Blanchardstown to City Centre Core Bus Corridor Scheme Submission (Ref. No. 313892)

Submitted on Behalf of:

Lissan Coal Company (Ireland) Limited
Unit 8, C Tek, Riverside Road, Carrickmacross, Co. Monaghan

30th August 2022

Drawing File Name: BCIDC-ARP-GEO\_GA-0005\_XX\_00-DR-CR-0028

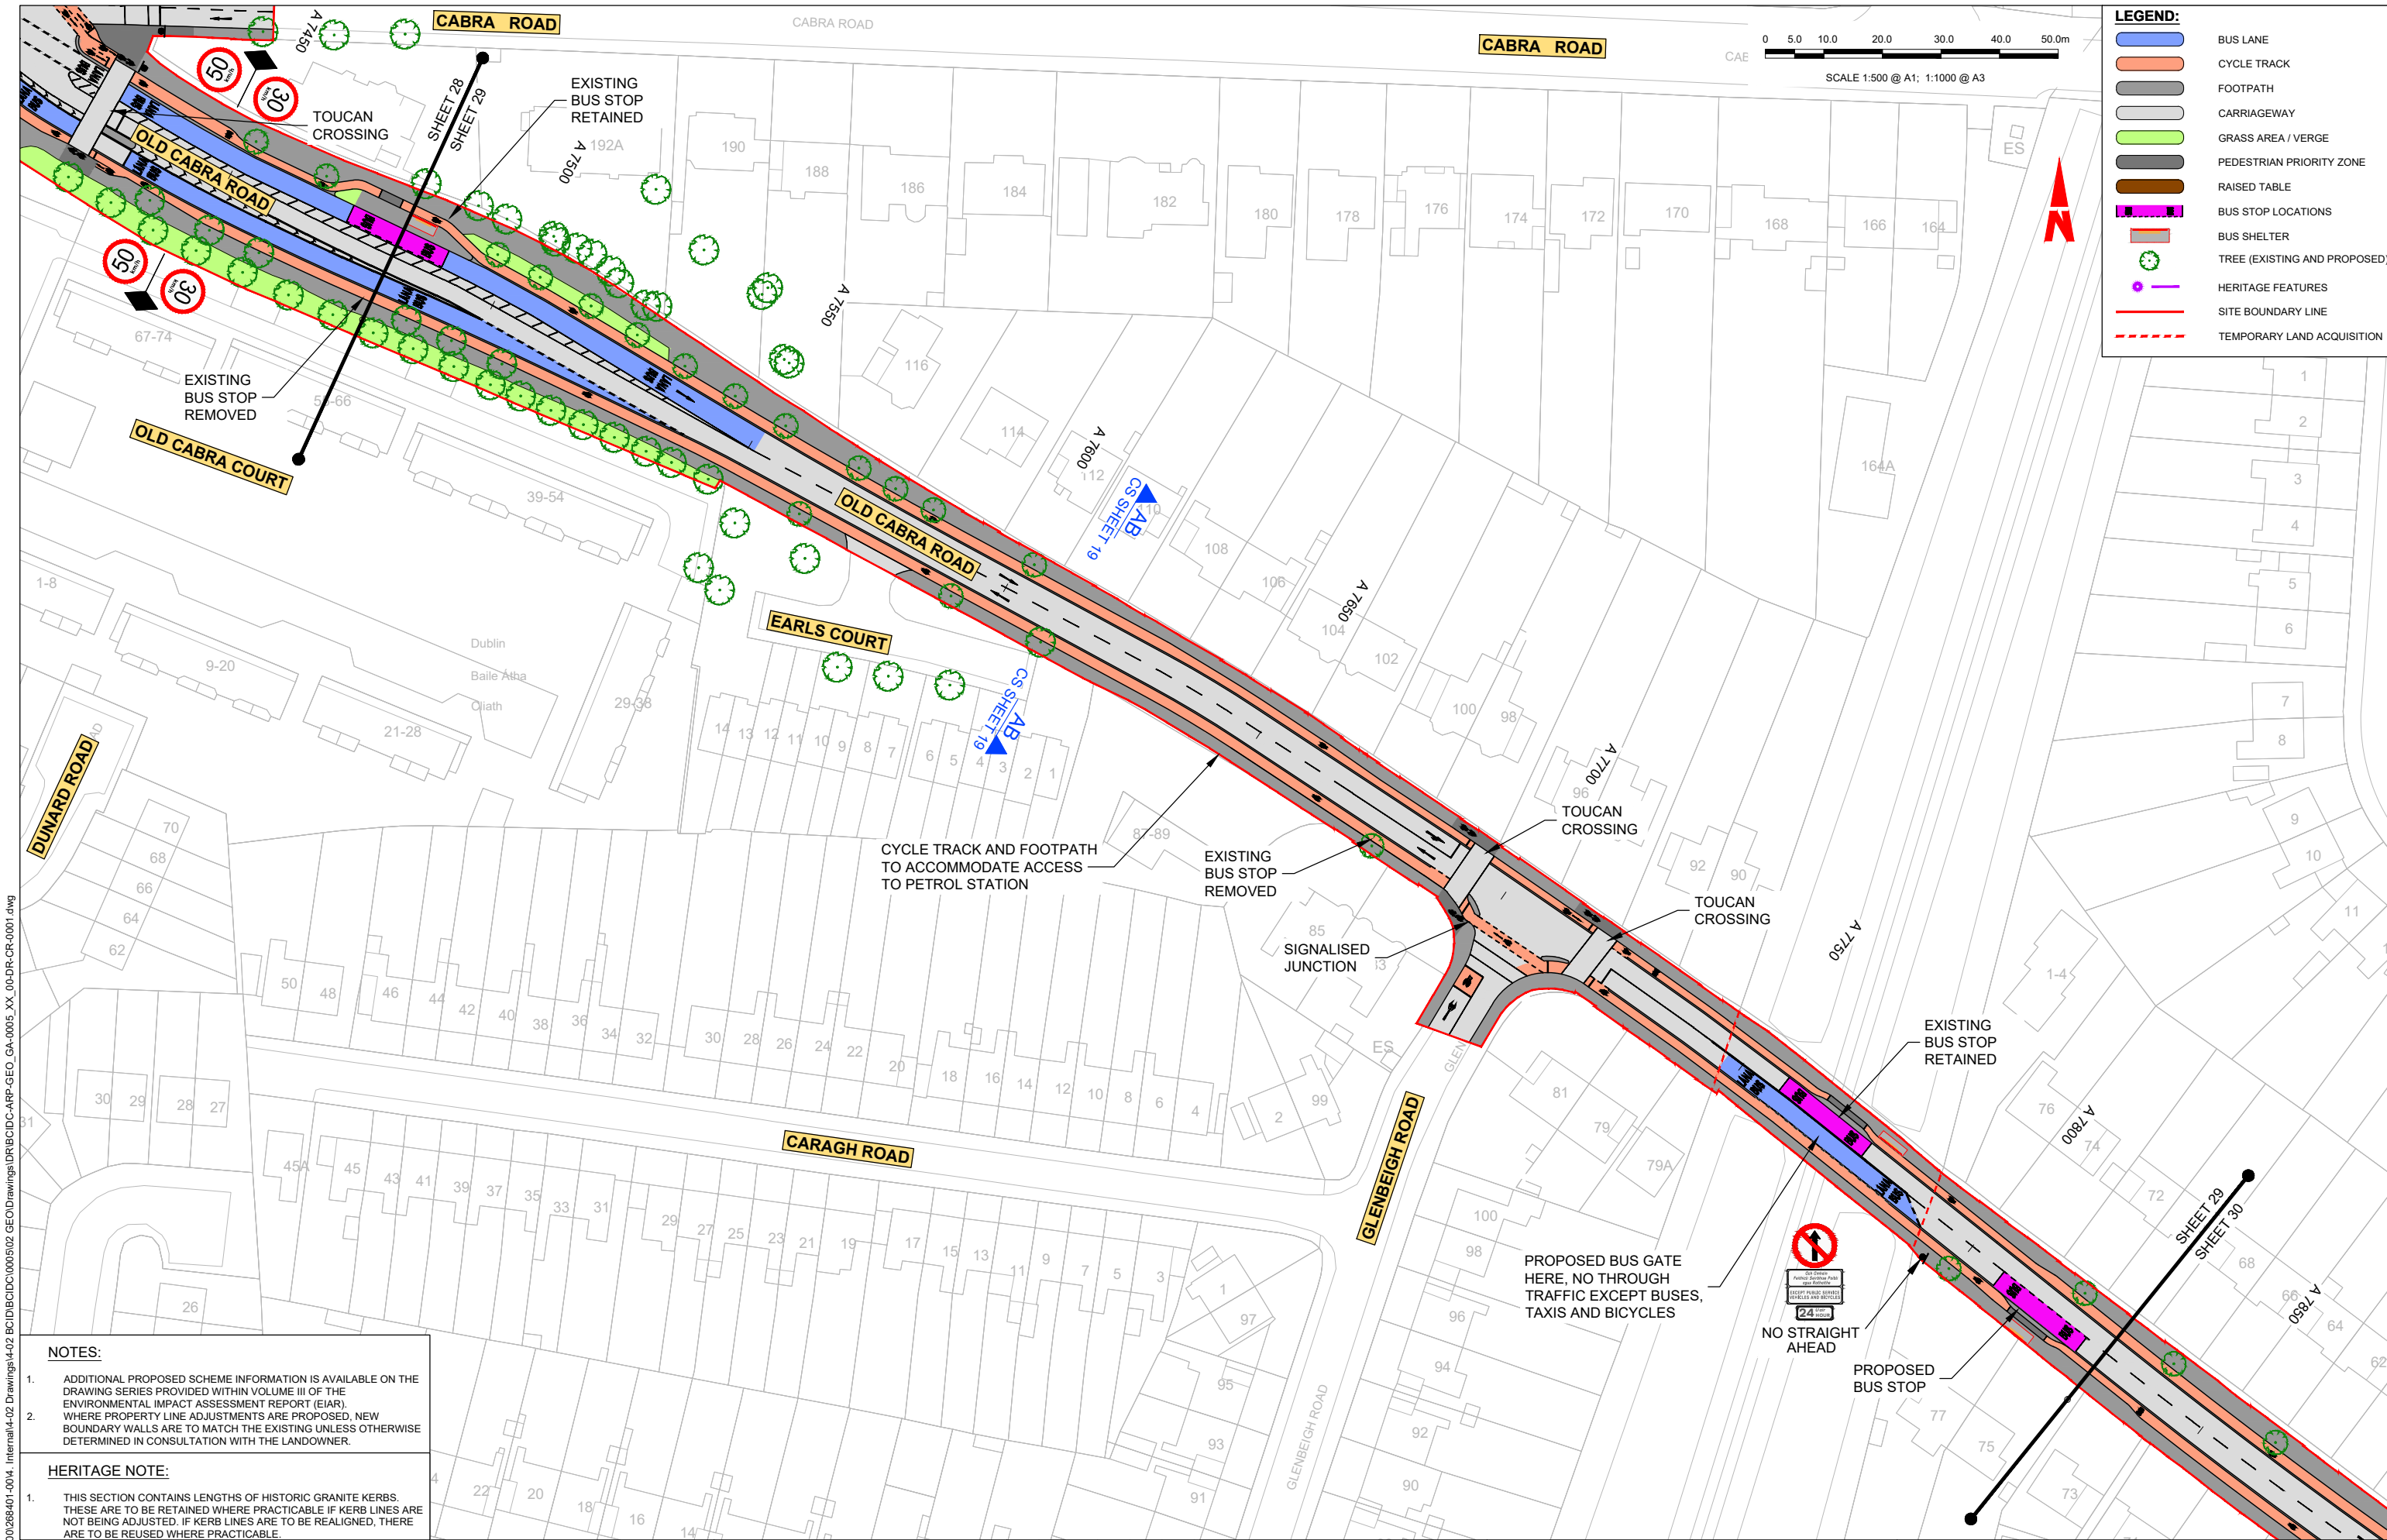
The bus gates, as identified in Figures 5.0-7.0 overleaf, will be in permanent operation and will prevent all through traffic from proceeding along this arterial route towards our client's site with the exception of buses, taxis and bicycles. Given the nature of the commercial use operating at our client's site, which is wholly based on continuously high volumes of passing vehicular traffic, the proposed bus gates present a catastrophic impact to the commercial viability of the site.

Figure 5.0 Extract from Sheet 28 of the General Arrangement drawing illustrating the proposed bus gate (red dashed line) at the junction of Navan Road, Cabra Road and Old Cabra Road.
